**WEST SUSSEX COUNTY COUNCIL
PLANNING SERVICES CONSULTATION**

SUBJECT: WA/75/17/PL-9 No. dwellings with associated car parking, bin storage & landscaping & creation of new access road from existing access onto West Walberton Lane. This application is a Departure from the Development Plan.

Land adjacent to Sunny Corner, Copse Lane, Walberton, West Sussex, BN18 0QH

Visiblity Splays
and Vehicle Swept Path Analysis

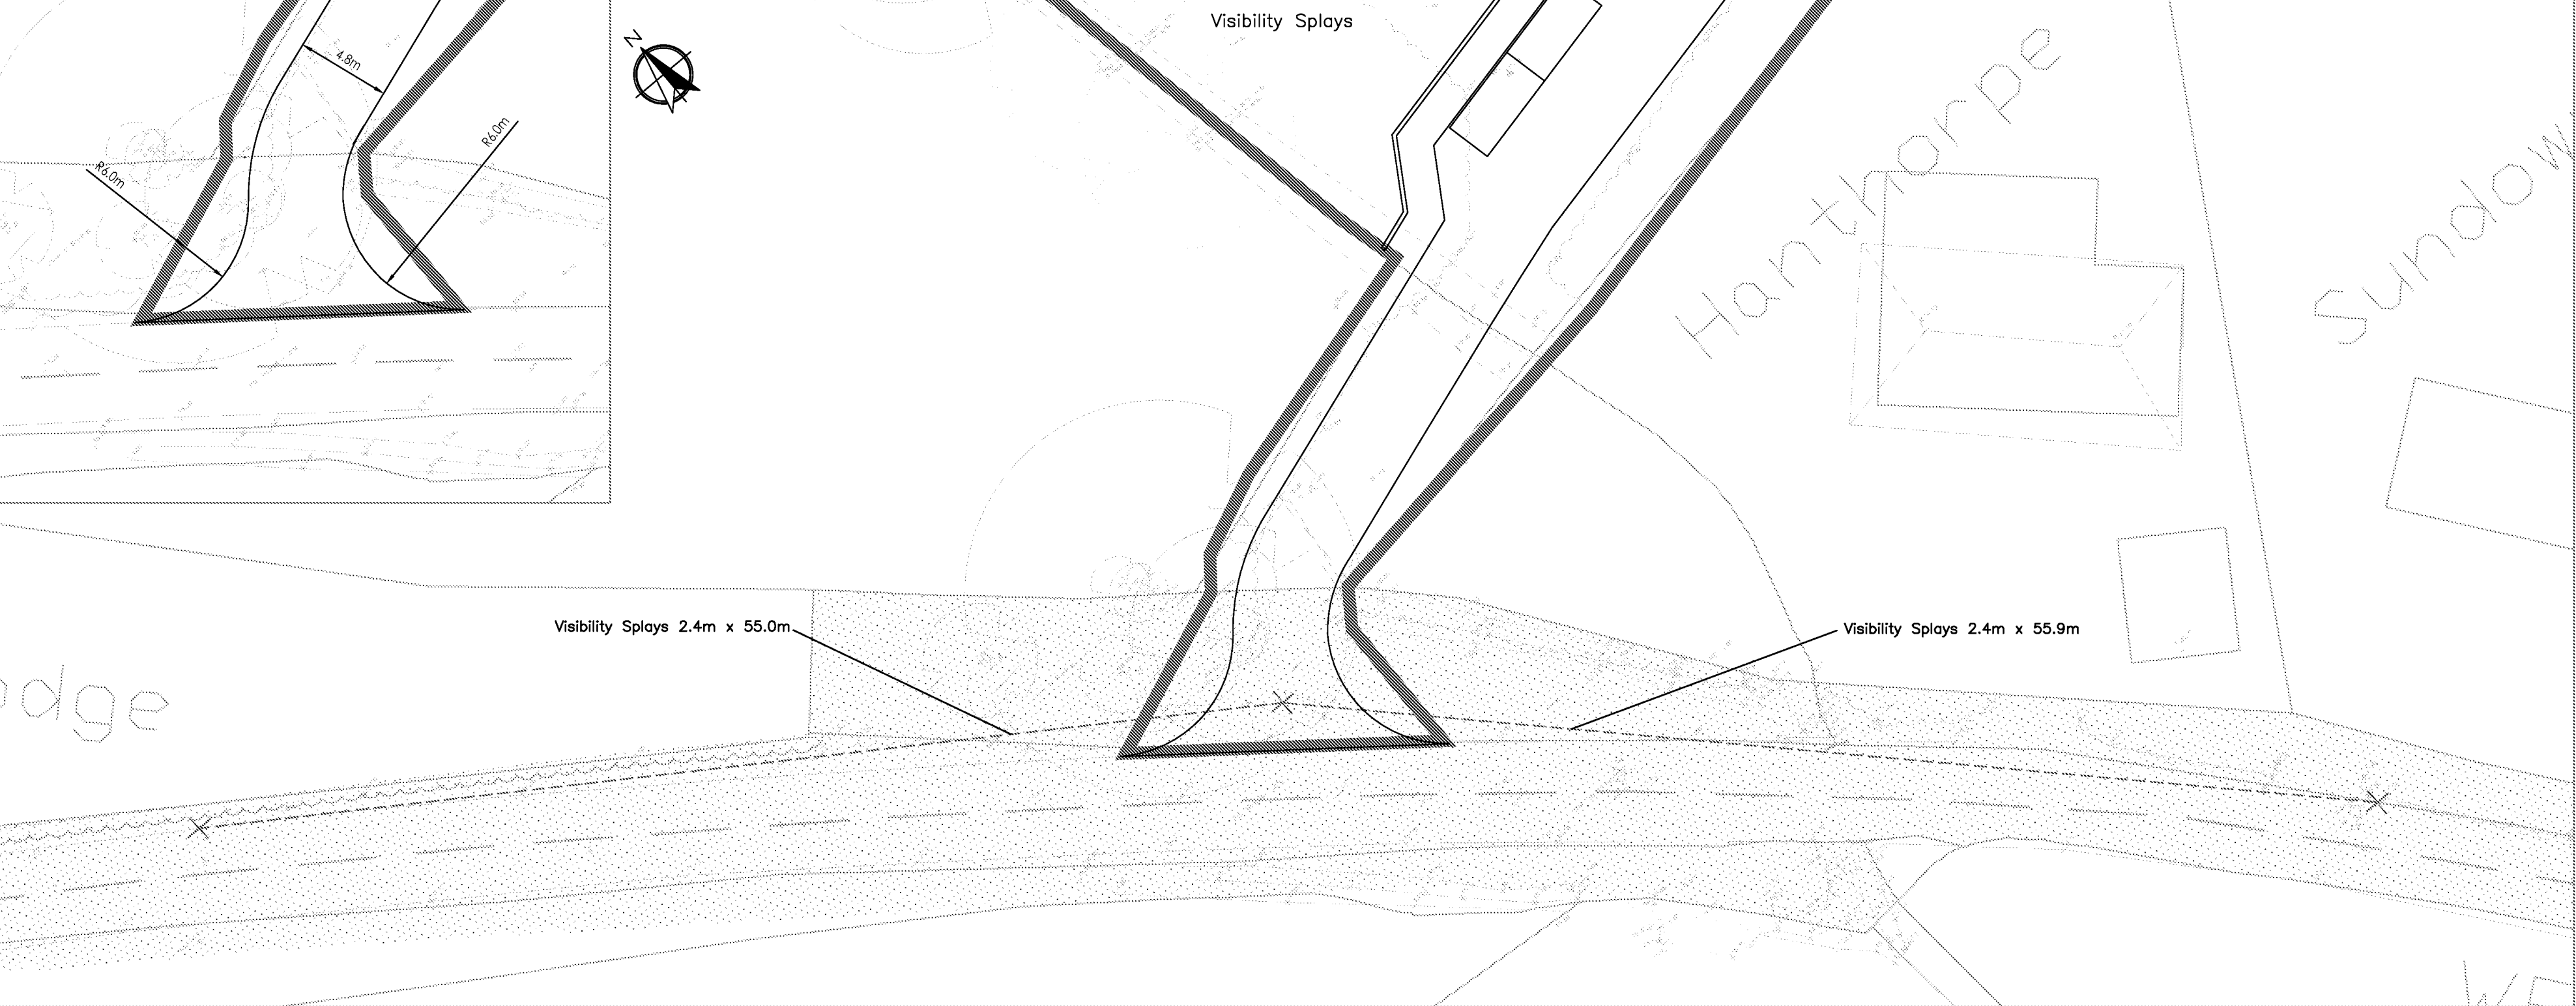
The site proposes a new access onto West Walberton Lane, the access will be 4.8 metres in width with 6 mere kerb radii. The access is considered to be of sufficient geometry to accommodate the anticipated level of vehicular activity. Sightlines along West Walberton Lane from the existing point are considered acceptable with splays of 85 and 83 me. These are based on speeds recorded were 36 mph northbound and 35.6 mph southbound.
